App Ref: WA/95/18/RES

Address Land east of Tye Lane, Walberton

Support

HT - A24L

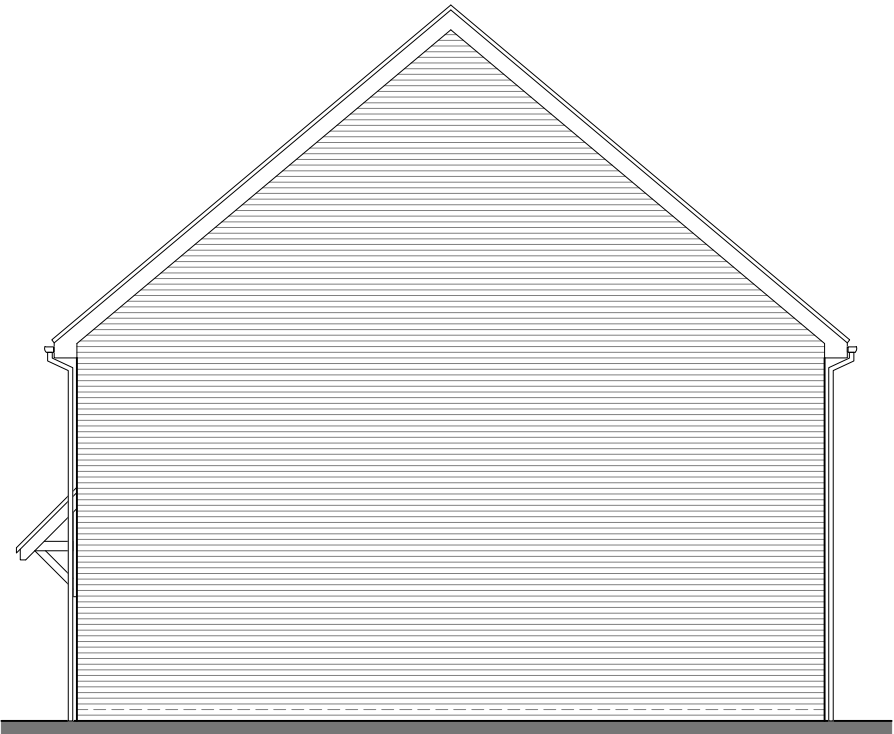
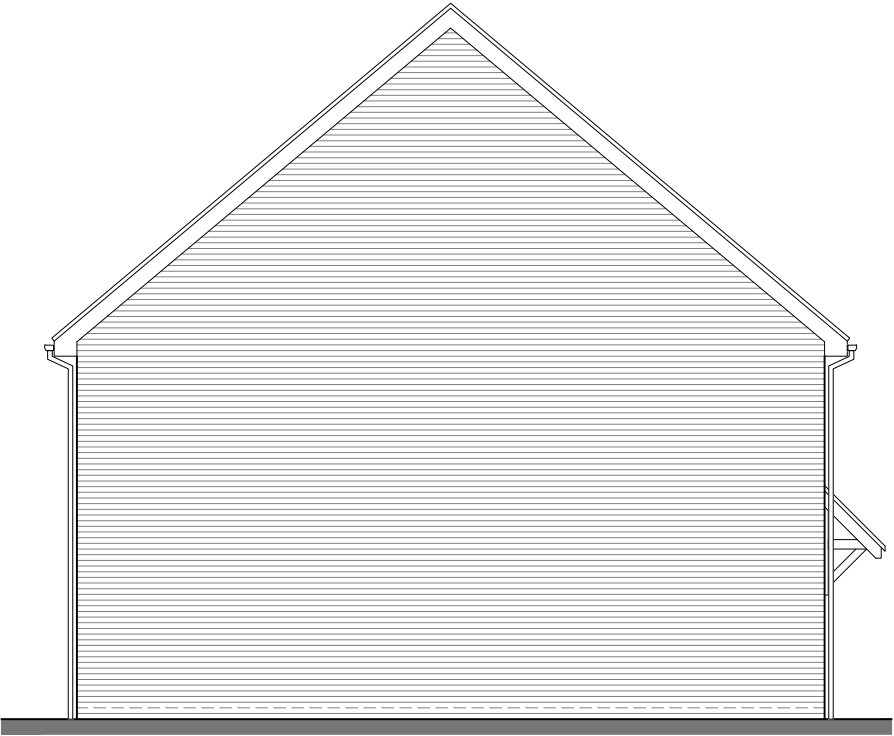
Of note are units 72-81 and 94, 95 and 96 due to their proximity to the conservation area/heritage assets. Having reviewed the plans, it is clear that the developer has attempted to improve the elevational treatment so that it reflects some of the established characteristics of the conservation area. For instance, units 74-81 are small scale, semi-detached cottages which front almost directly on to the carriageway.

The success of those properties (which are located within close proximity to the conservation area) will ultimately be related to the quality of the materials used. Every attempt should be made to ensure that the materials used reflect the colours and textures of those found in the conservation area.
